From: Geoff [REDACTED]
Sent: 02 July 2019 09:29
To: [REDACTED]
Subject: Applications AB/48/19/PL and AB/49/19/L

Further to our email of 27th June I write in order to submit the following revised drawings:

Please accept the above drawings as amendments to applications AB/48/19/PL and AB/49/19/L

A6001-08A

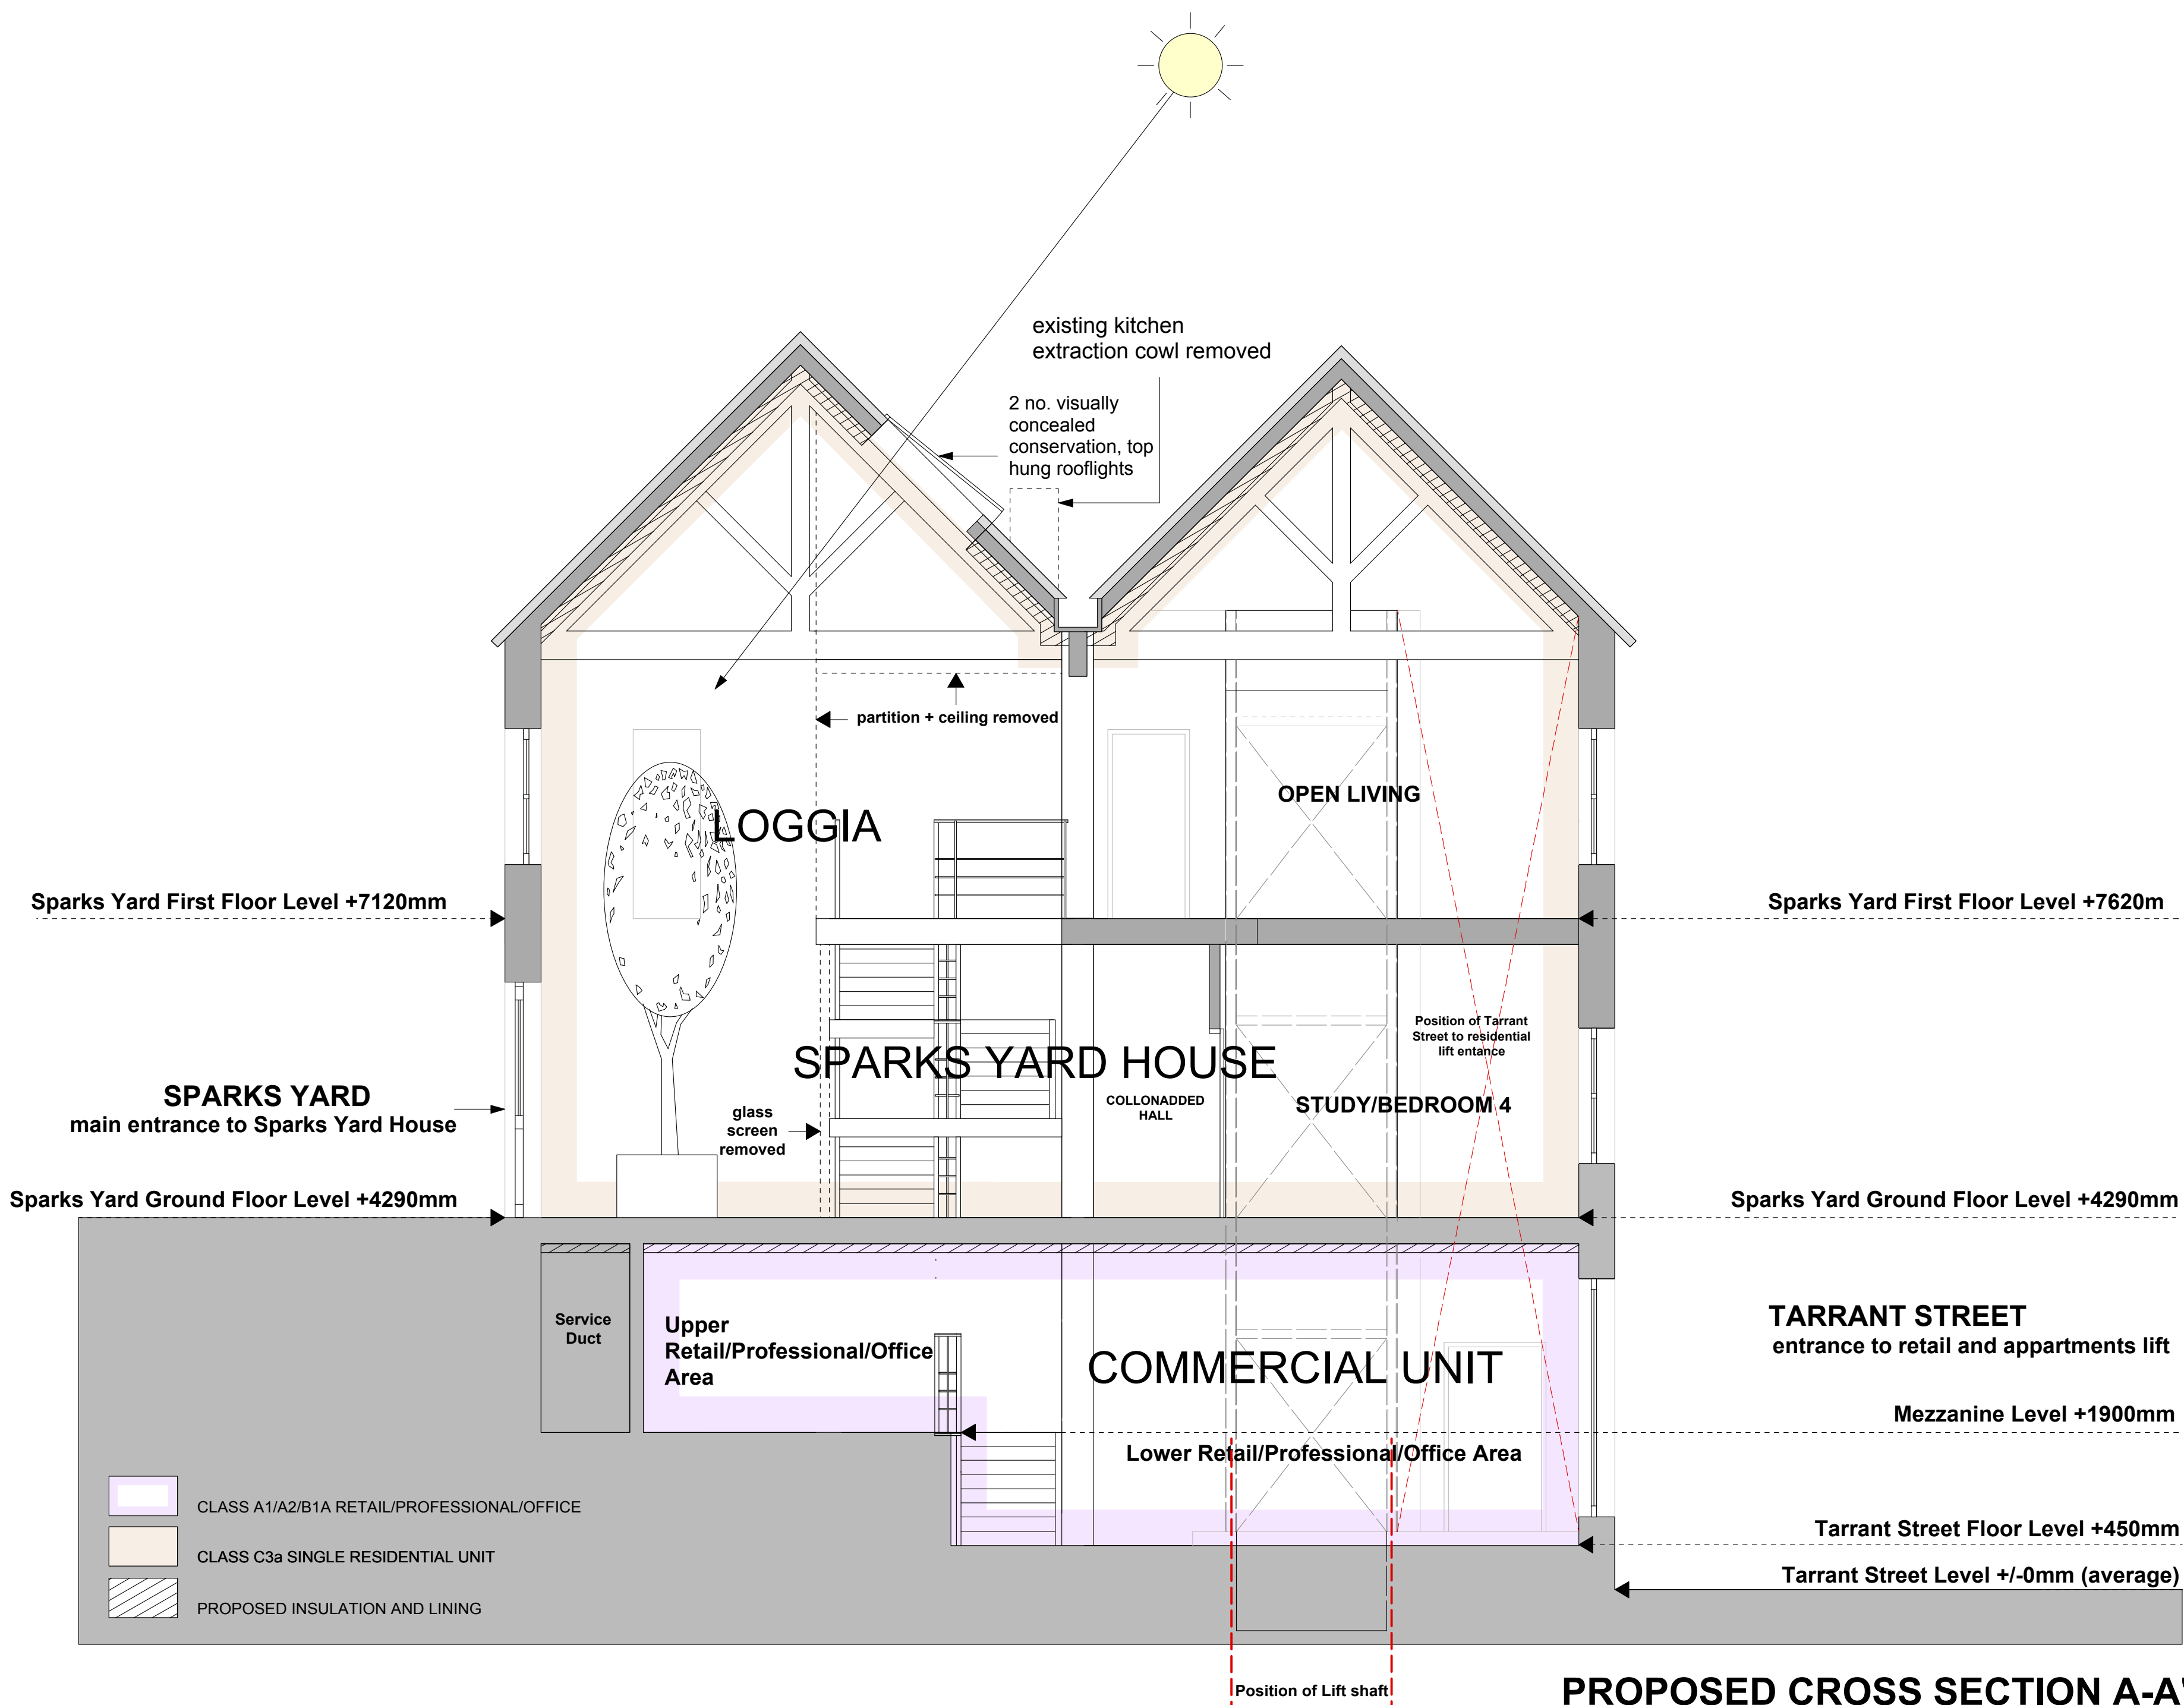
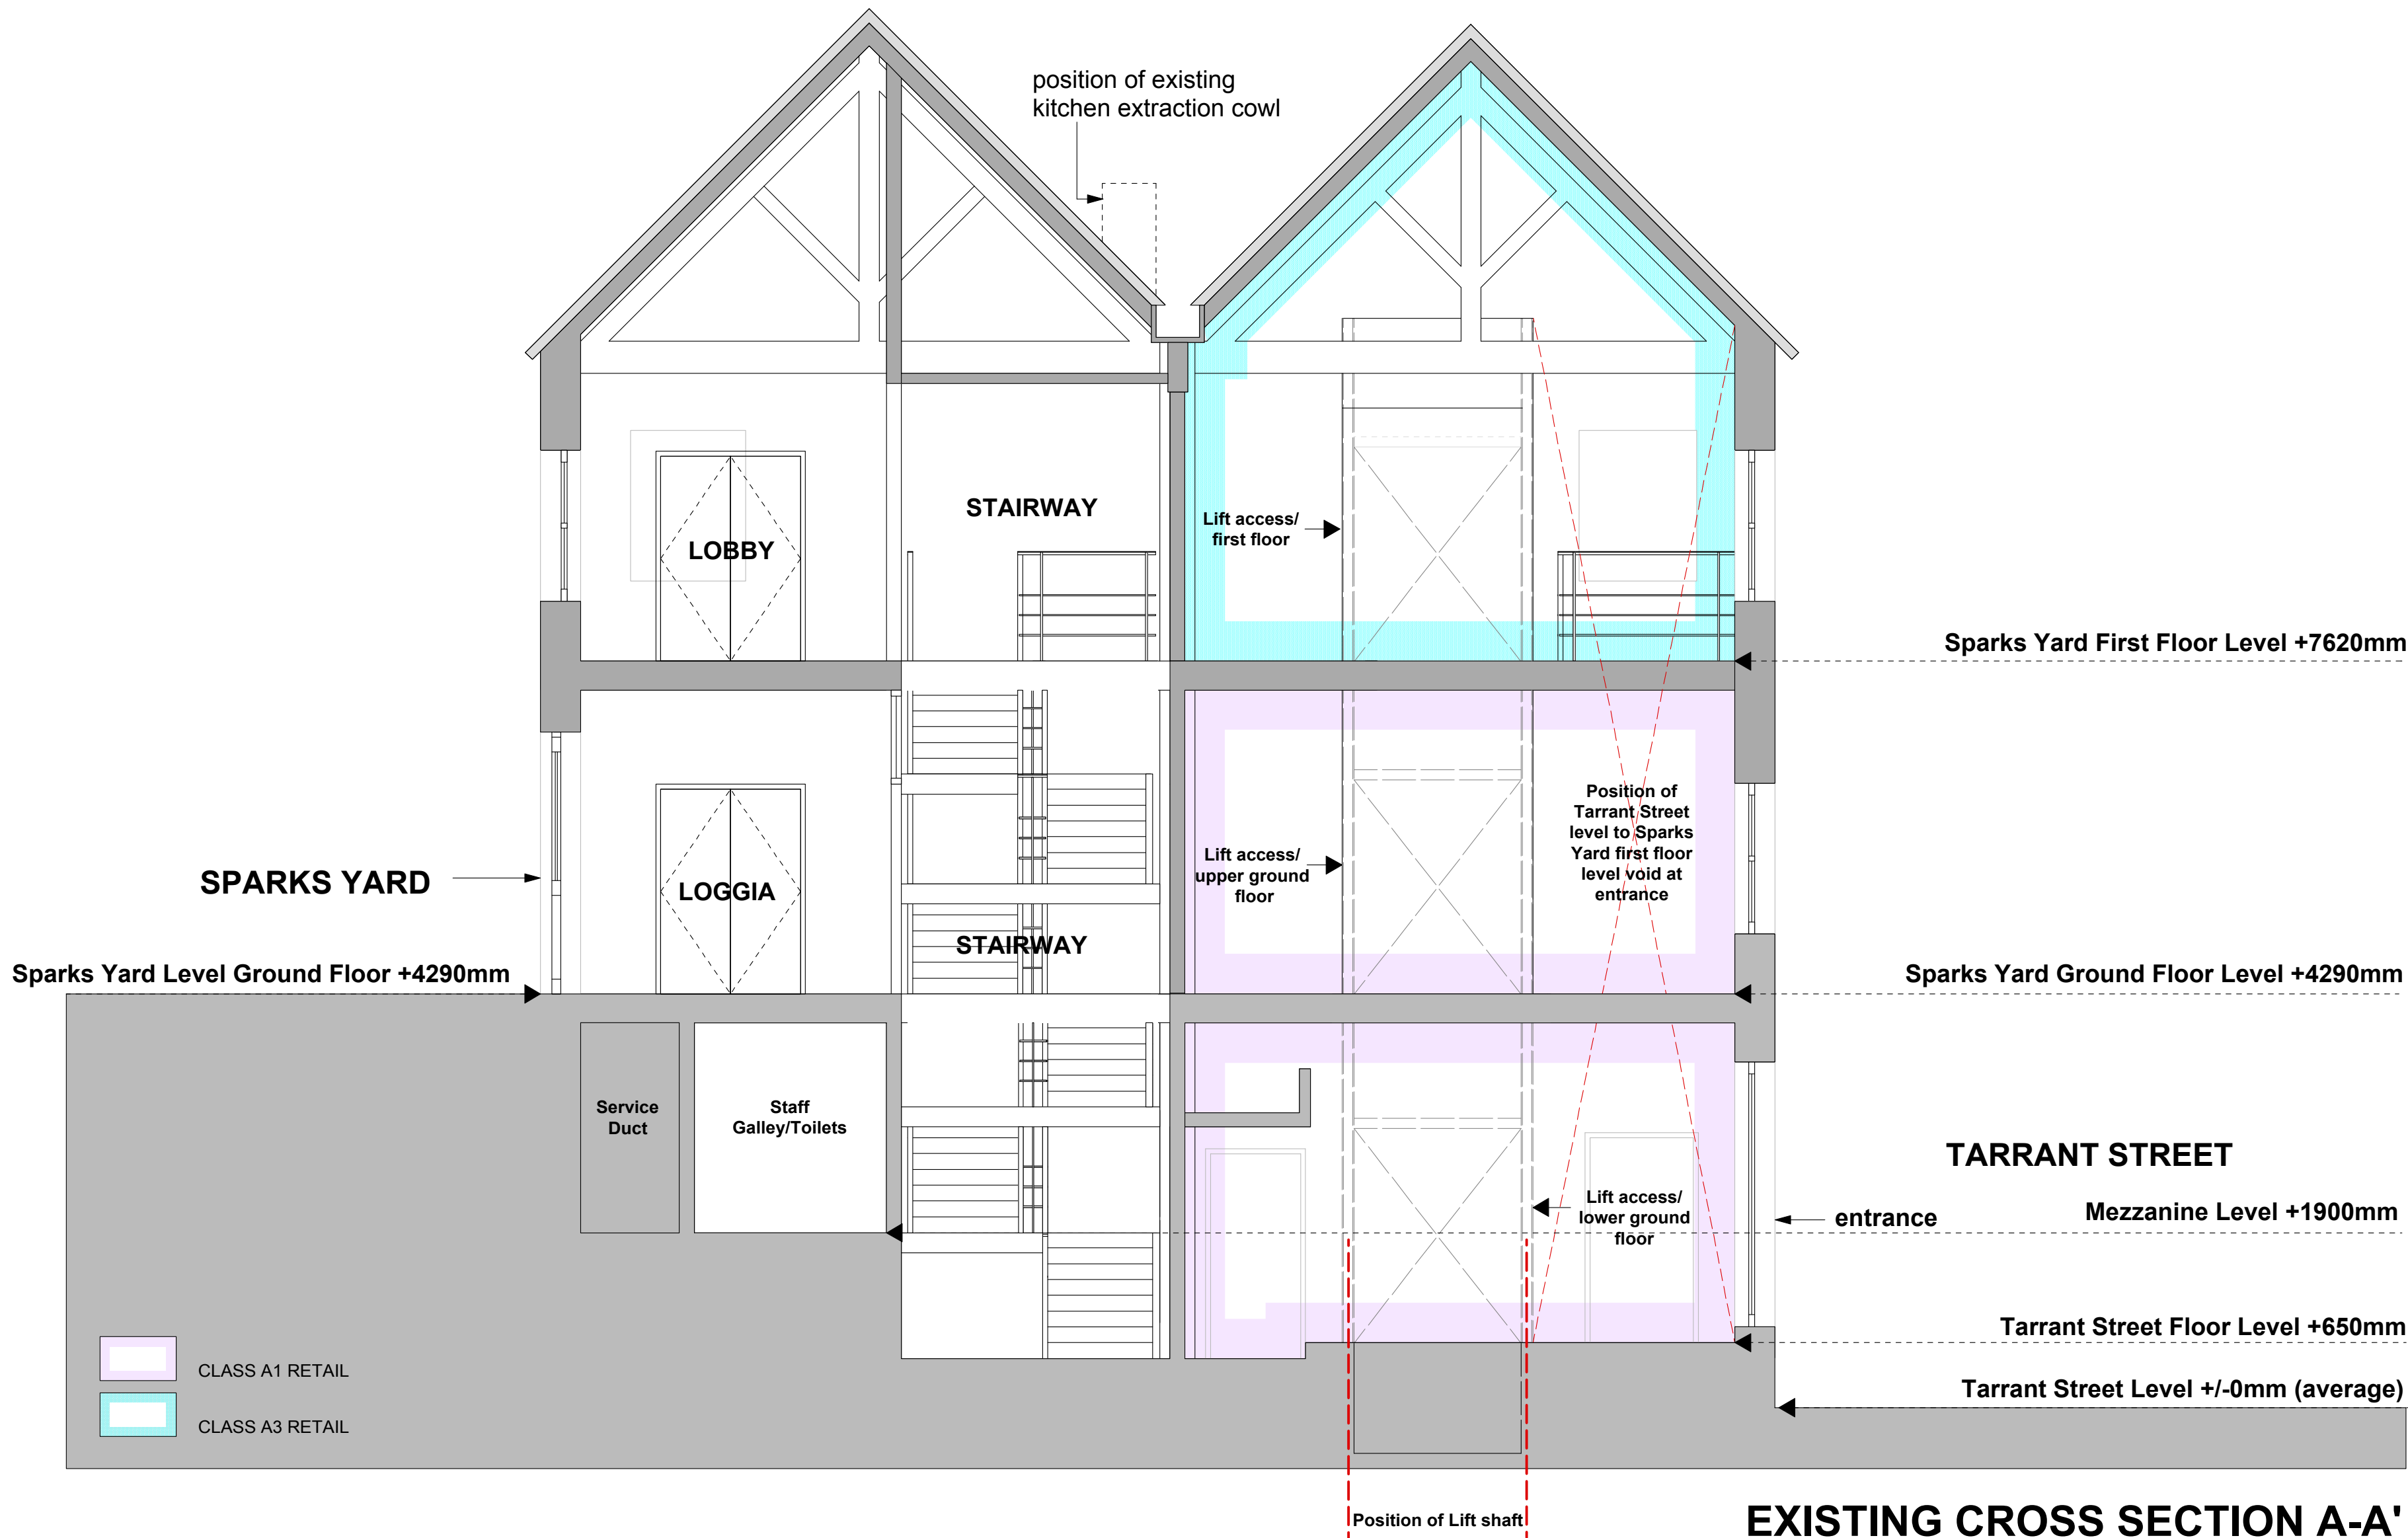
Drawings A6002 -05 Revision A, -06 Revision A and -08 Revision A.

All three drawings are revised, removing the previously proposed plasterboard faced, insulated internal wall linings to the upper two floors of the building.
